From: [Mau, Russell E \(DOH\)](#)
To: [Rachael Stevie \(CD\)](#)
Cc: [Smits, Brenda M \(DOH\)](#); [Holly Erdman](#)
Subject: RE: RU-22-00002 East Peak - Notice of Application
Date: Thursday, April 7, 2022 11:42:18 AM
Attachments: [image001.png](#)

The Department of Health (DOH) Office of Drinking Water (ODW) has the following comments:

EXHIBIT A - PROPOSED SITE PLAN

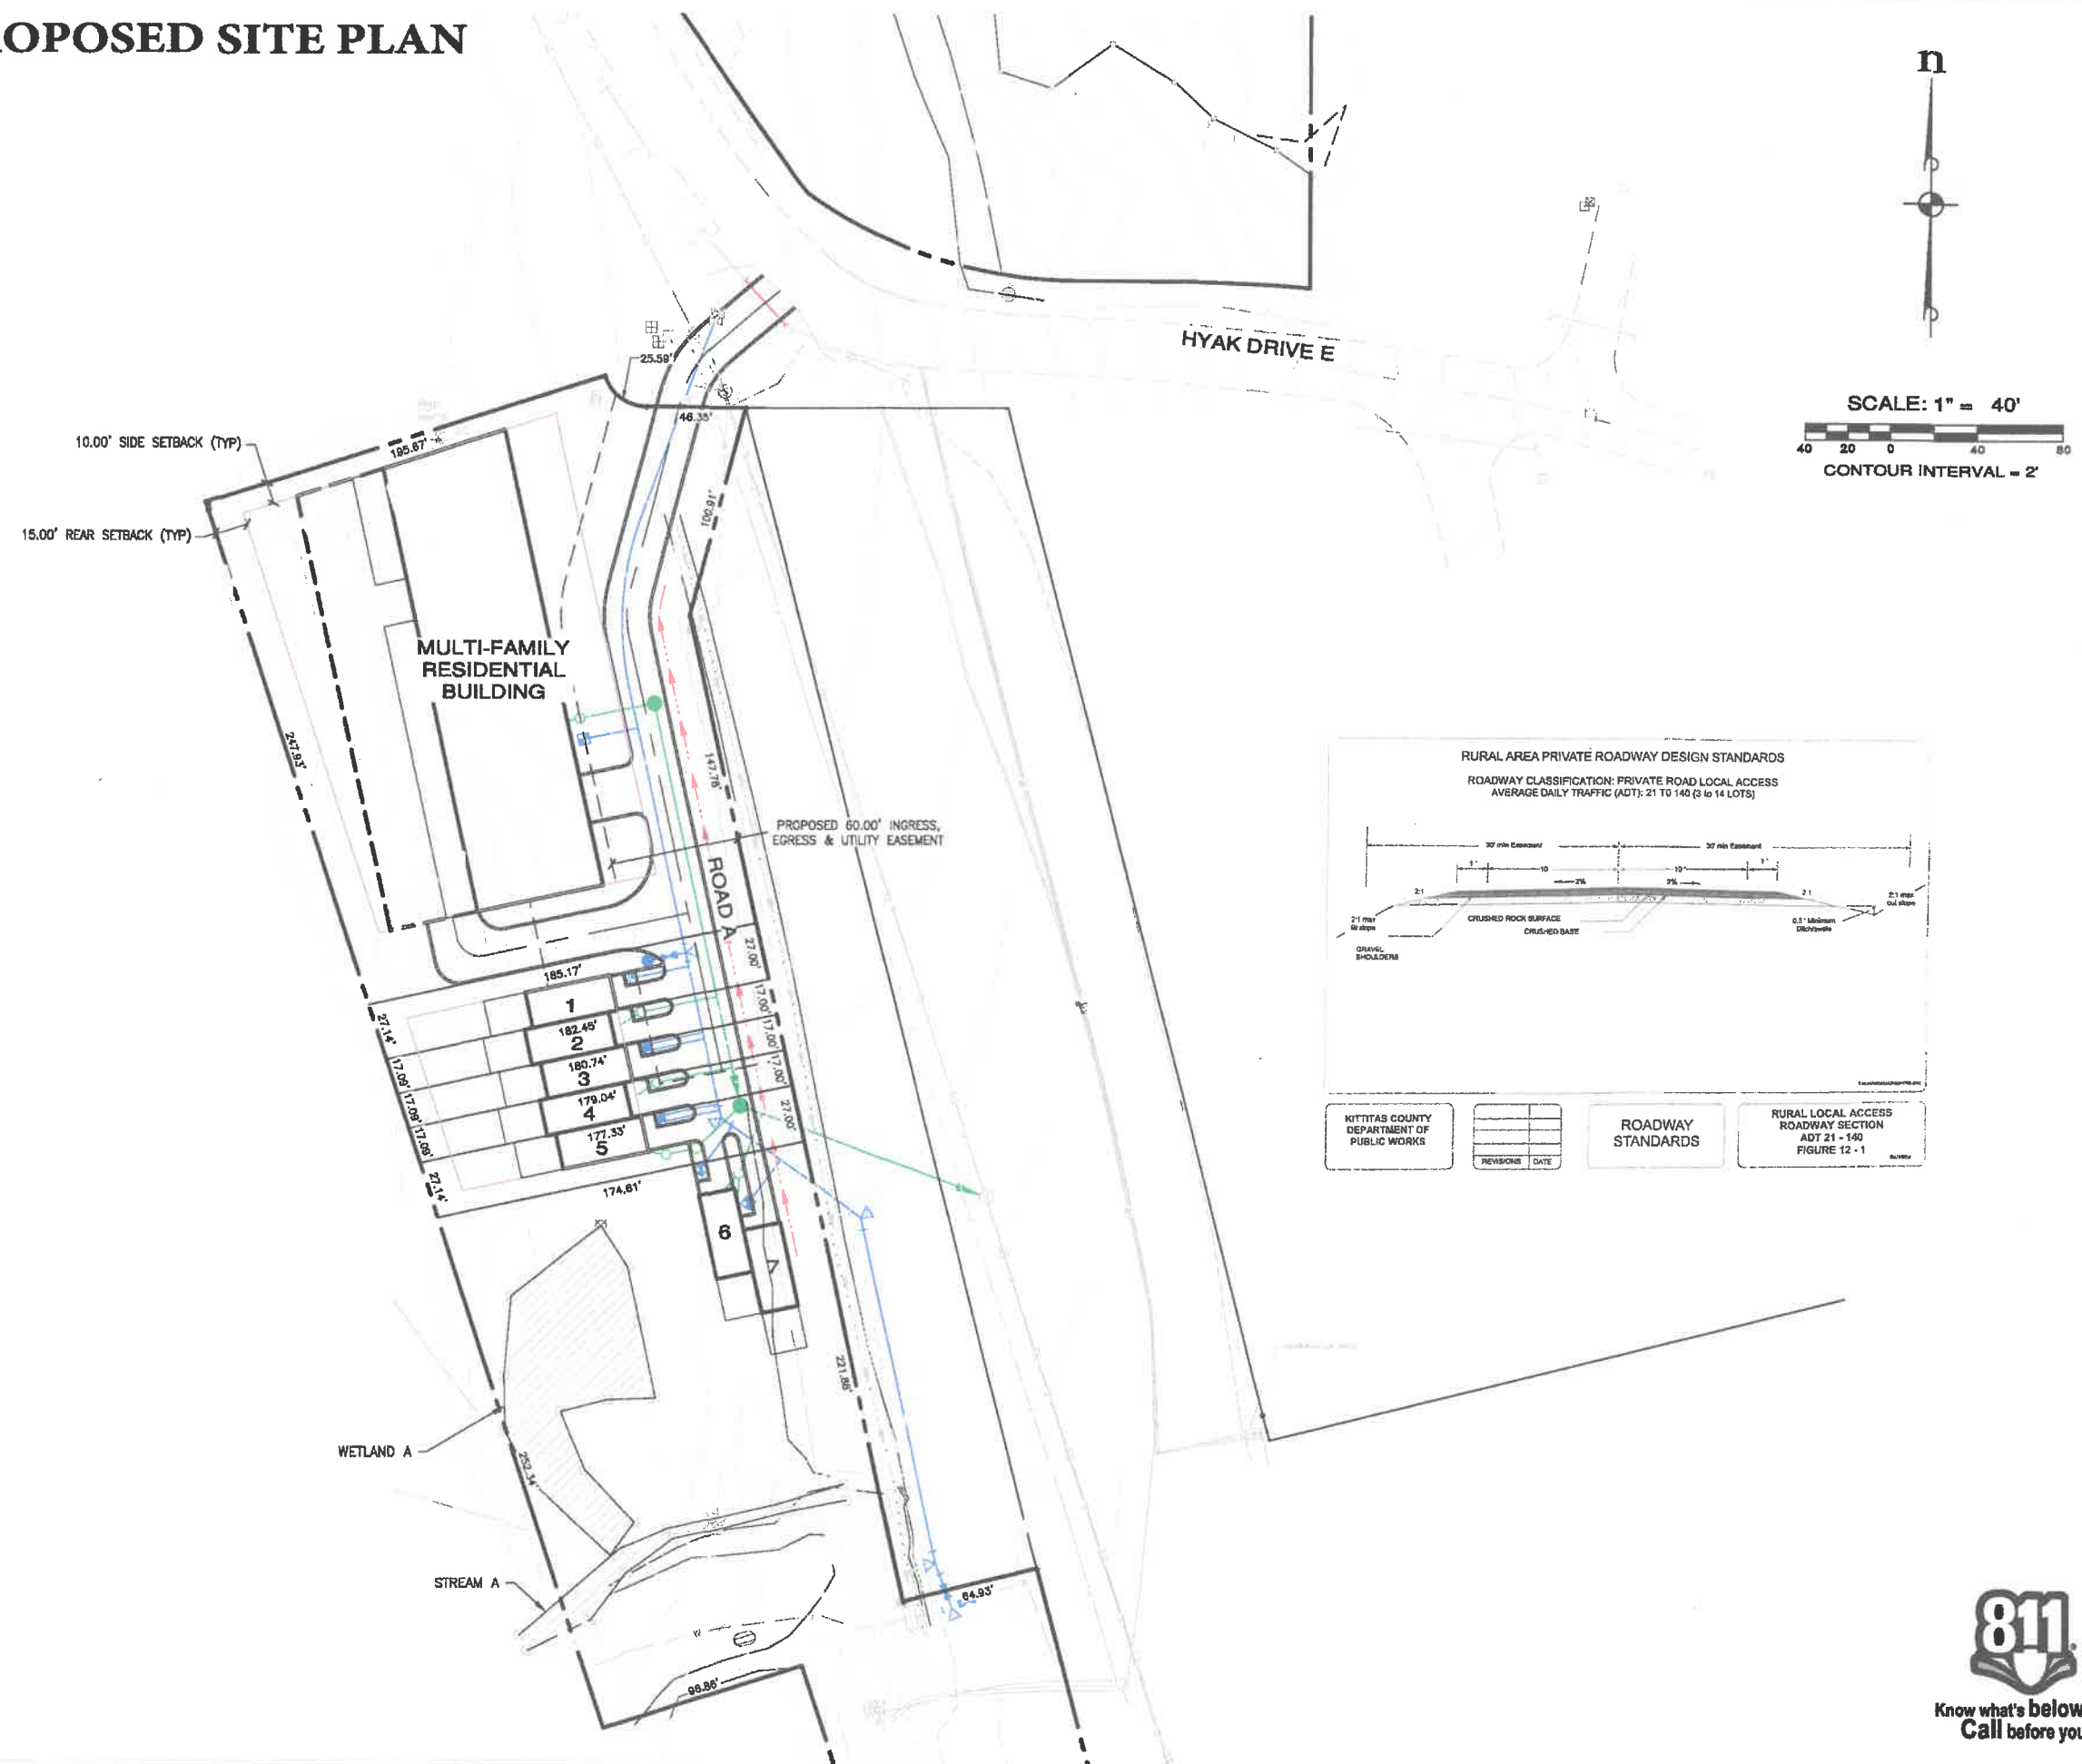
- While the applicant is seeking “Reasonable Use” exceptions, and DOH ODW has no comment on that, DOH ODW would like to know how the proposed buildings are being served drinking water.
